November 20, 2018

SUBJECT: **Request for Modification of Section 404 Individual Permit and Section 401 Water Quality Certification** for the proposed Winston-Salem Northern Beltway Eastern Section from US 158 to I-40 Bus/US 421, Forsyth County, Division 9. WBS Element No. 34839.1.2, TIP Project No. U-2579B.

**Reference:** Section 404 Individual Permit – Action ID No. SAW-2008-03183, issued June 17, 2014 and modification issued July 2, 2014.  
Section 401 Water Quality Certification – NCDWR Project No. 2014090 issued April 11, 2014 and modification issued July 28, 2014.

S S DENOTES IMPACTS IN SURFACE WATER

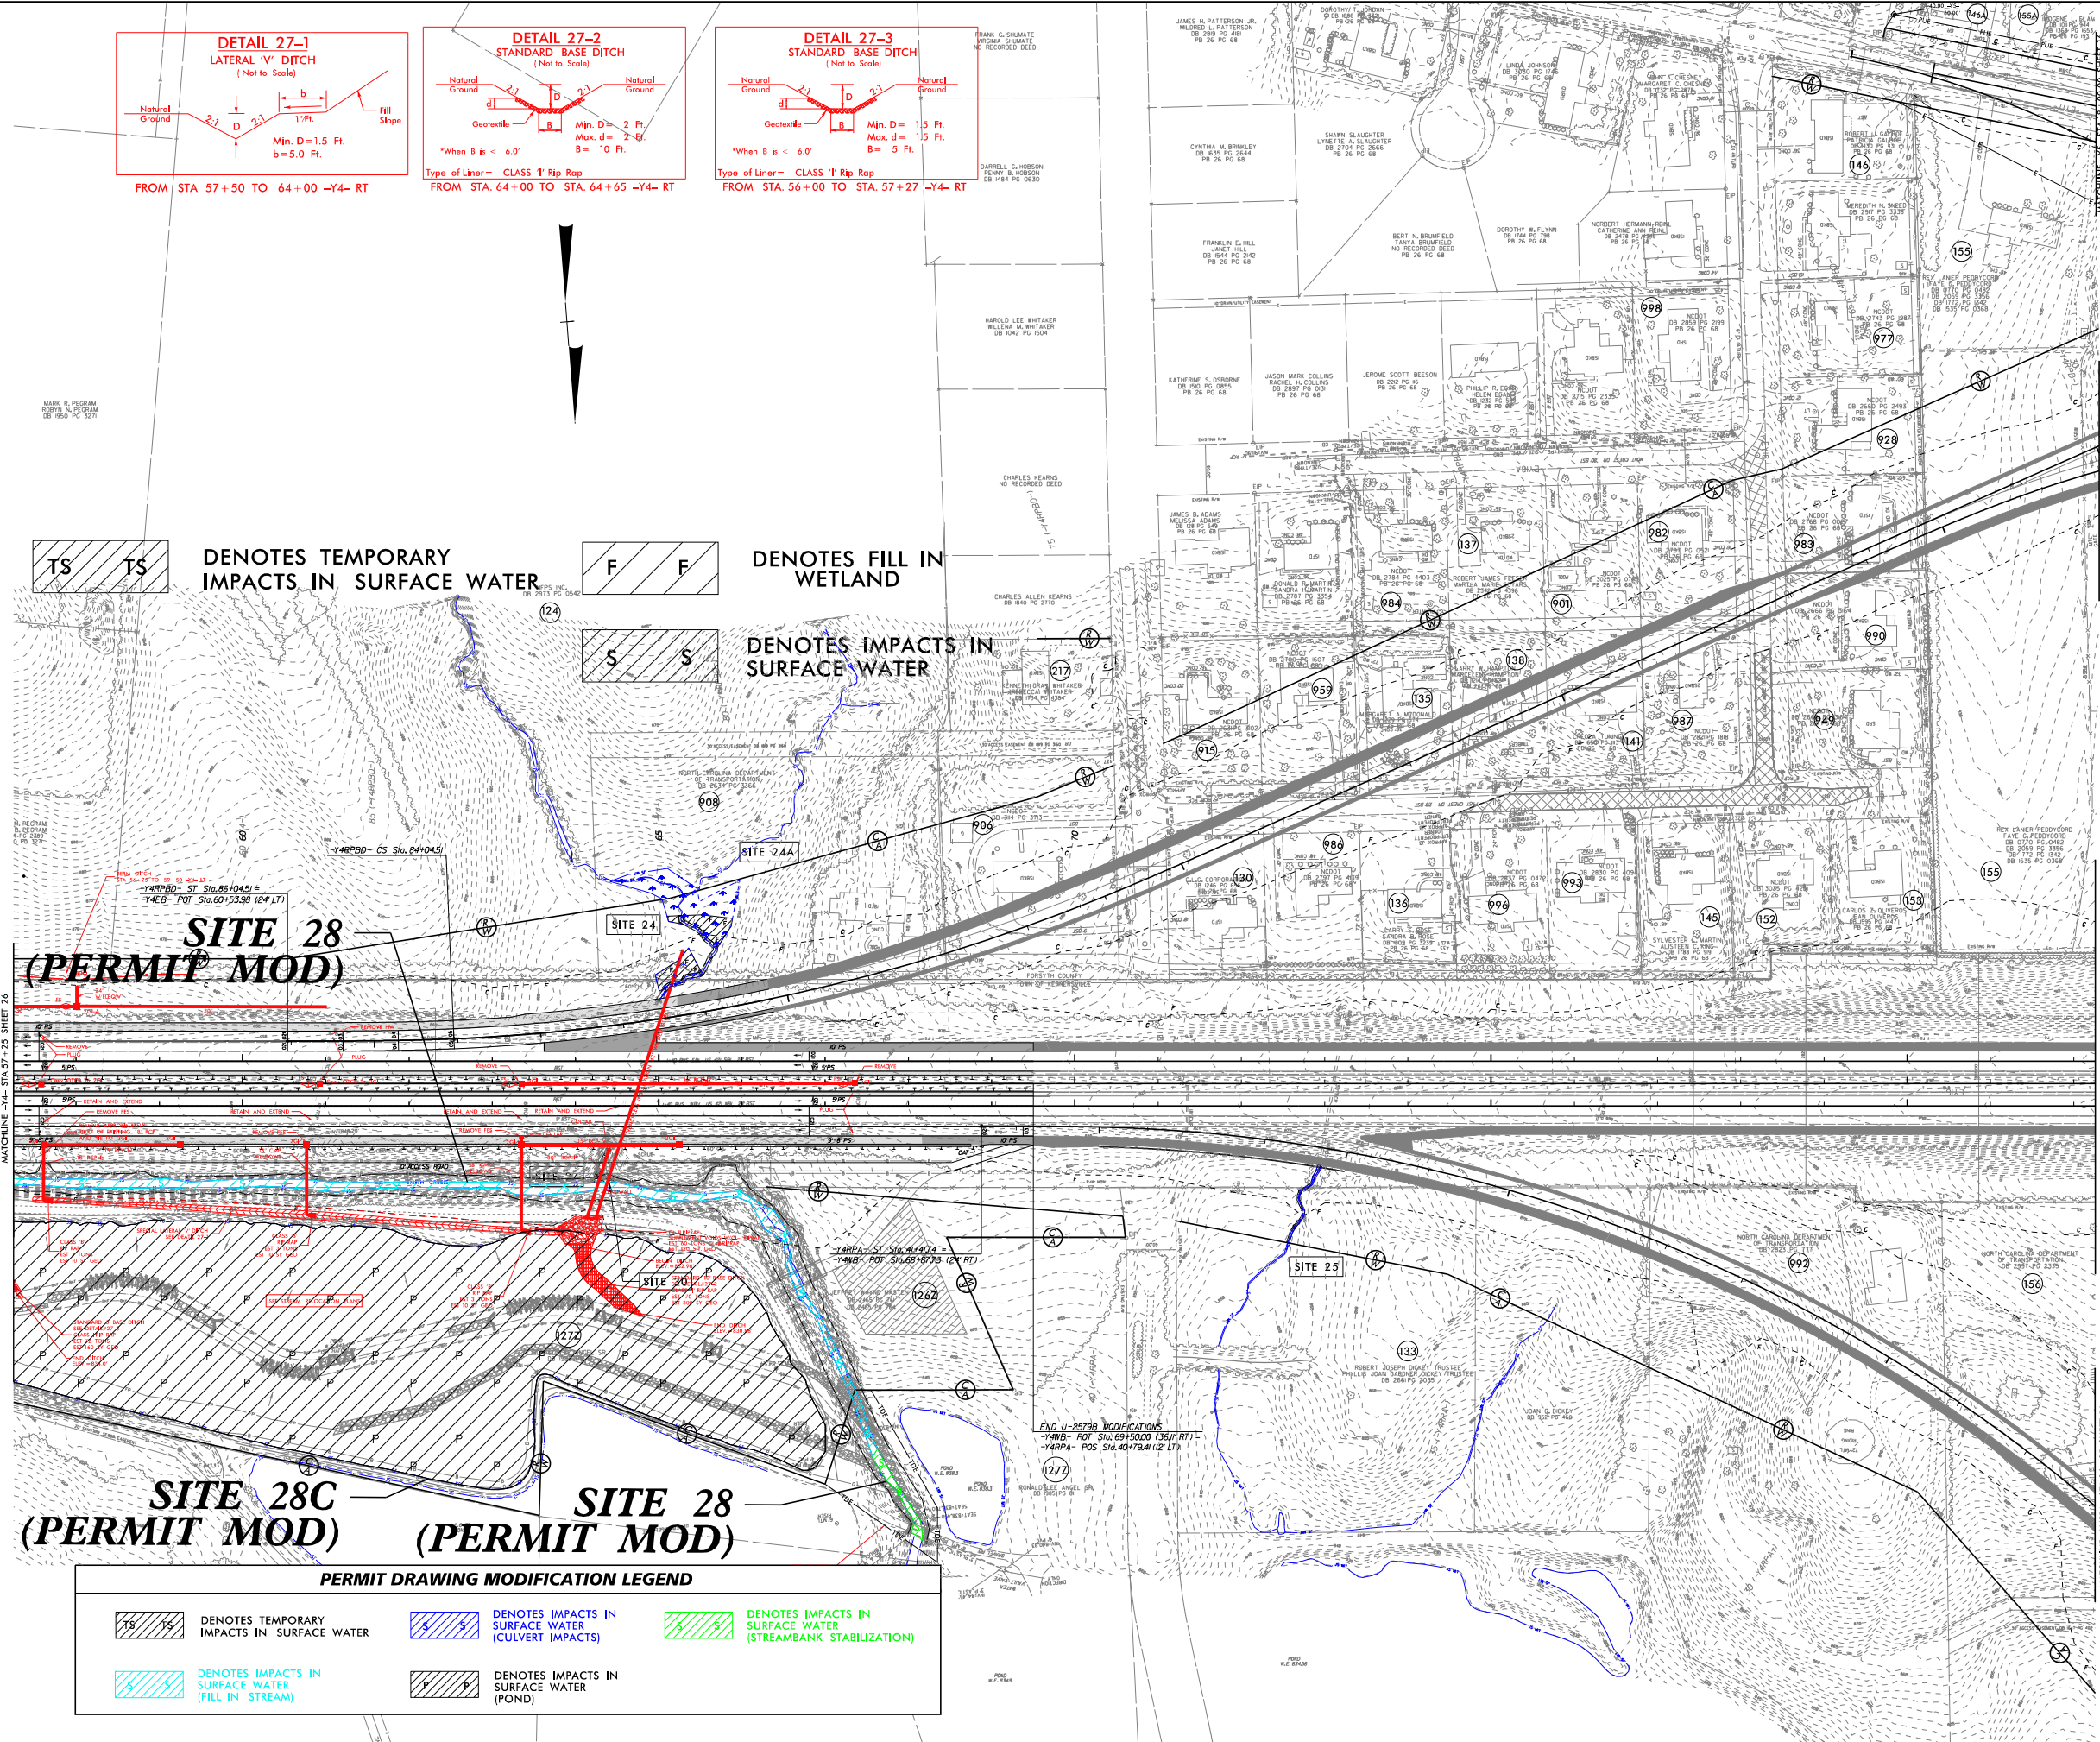
At permit site 28, the low flow barrel will not be buried 1' below the stream bed. The bed of Smith Creek has a predominately bedrock bottom making culver burial infeasible. There will be a spill over channel constructed on top of the exposed portion of the culvert, and it will be lined with Armorflex in the event of overtopping. The outlet of the low flow barrel will have a rip rap pad of Class II to prevent scour in the event of overflow. The 2 high flow barrels will have 1' concrete sills at the inlet and outlet. Floodplain benches will be constructed with Class II rip rap at the inlet and outlet. The high flow barrels will be backfilled with native material and/or Class I rip rap.
